2024/0259

Erection of 5 no. dwellings with associated access, parking, landscaping and other infrastructure works

Land off Dodworth Green Road, Dodworth, Barnsley

### Tree Protection Fencing

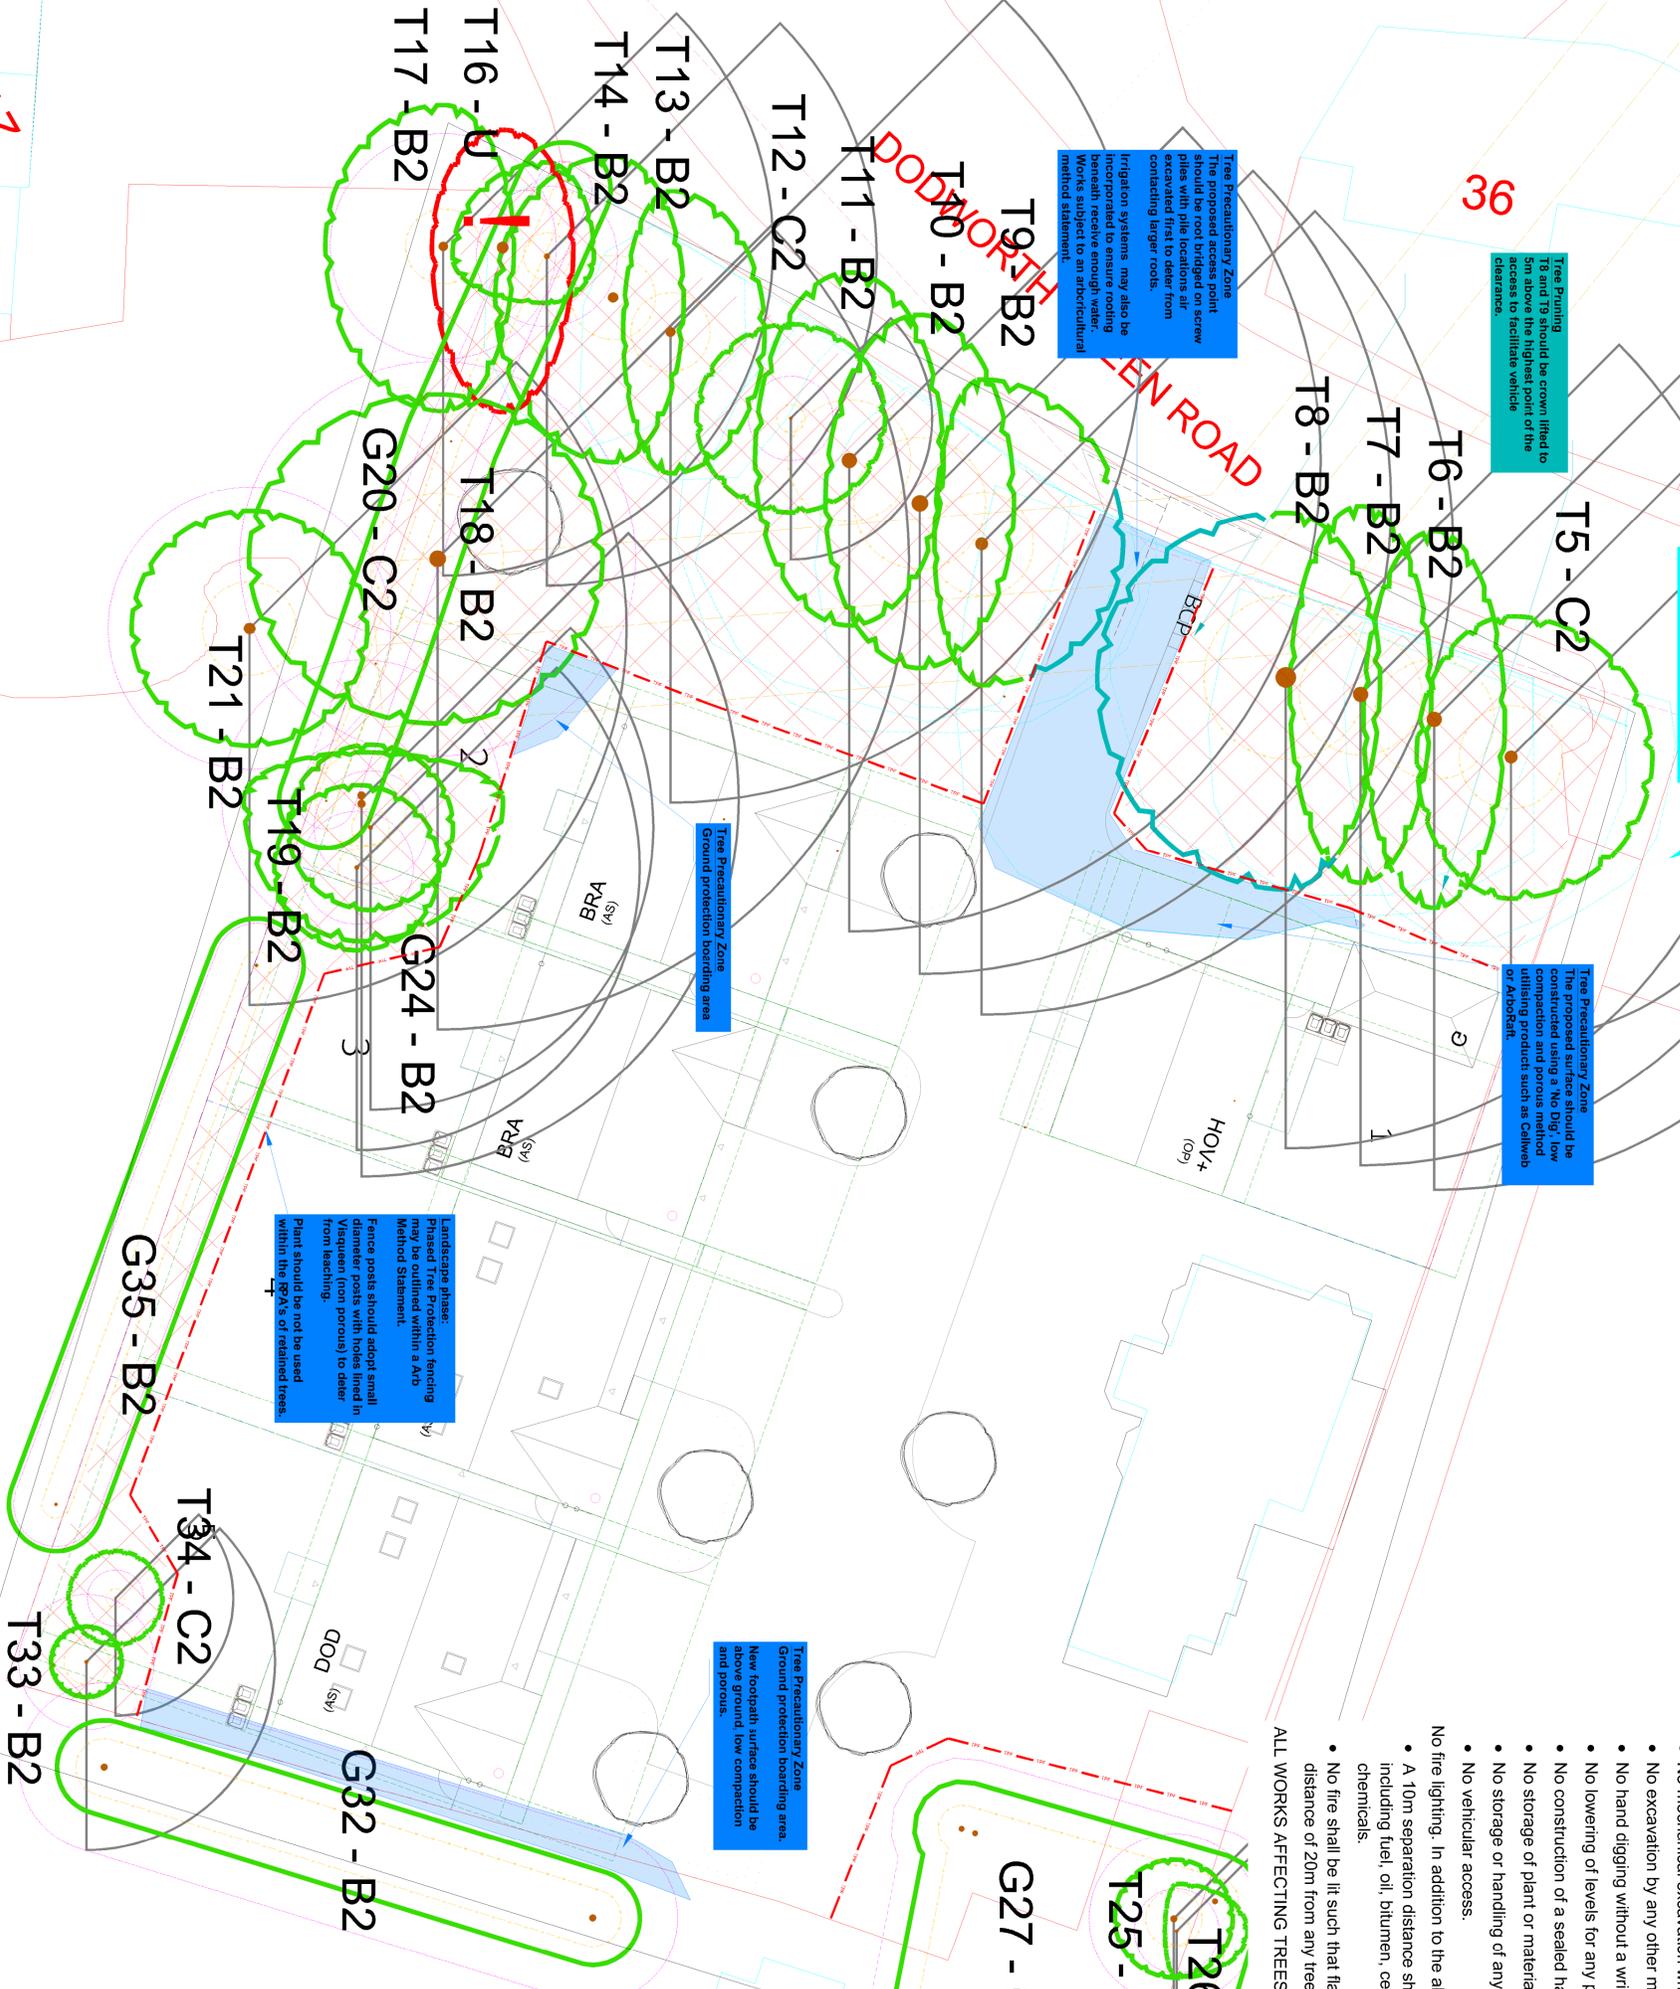
The development would significantly harm the rooting area of trees T8 and T9 which are protected by TPO No: 7 by virtue of the vehicular access installation. The rooting area would be covered by hard surfacing, with changes to the site levels proposed at either side of the existing boundary wall. This would severely impact the retained trees.

The proposed dwellings would be heavily overshadowed by the retained trees, particularly Plots 2 and 3, with all morning sunlight blocked at these proposed dwellings. This would result in severe pressure to prune or remove the retained trees once the proposed are occupied. In summary the development results in a significant impact upon trees.

The development includes creating a vehicular access between trees T8 and T9, both of which are protected category B horse chestnut species. Works to the trees involve lifting the crown to 5.2m to enable the vehicle access beneath. The extent of the canopy works is indicated on the AIA Plan above (indicated in blue).

Whilst it is recognised that there is a natural gap between the stems of the two trees, the proposed private drive would overlay the root protection area for both trees. The rooting area of T8 would be significantly impacted due to the private drive and then the driveway for Plot 1 wrapping around the canopy of the tree. The installation of tarmac surfacing (as shown on the materials plan) would impact water percolation and harm the health of the protected tree. This is strongly discouraged and is discordant with Paragraph 6.2 of the adopted trees and hedgerow SPD.

The AIA Plan (included above) indicates the extent of the shadows created by the trees to be retained (grey lines). The plan demonstrates that the trees along the south-western corner of the site, including T18, T19, T21 and G24 in particular would severely impact Plots 2 and 3 in terms of overshadowing. The rear elevations of the proposed plots would be positioned to the north of those retained trees meaning overshadowing would impact the dwellings and gardens due to the sun path. The plan demonstrates that the entire rear elevation of both plots would be overshadowed, meaning insufficient natural light would serve the windows on this elevation which includes bedrooms 3 and 4 plus the study room. Additionally Plot 2's rear garden would be entirely overshadowed, whilst Plot 3's garden would also be significantly impacted.
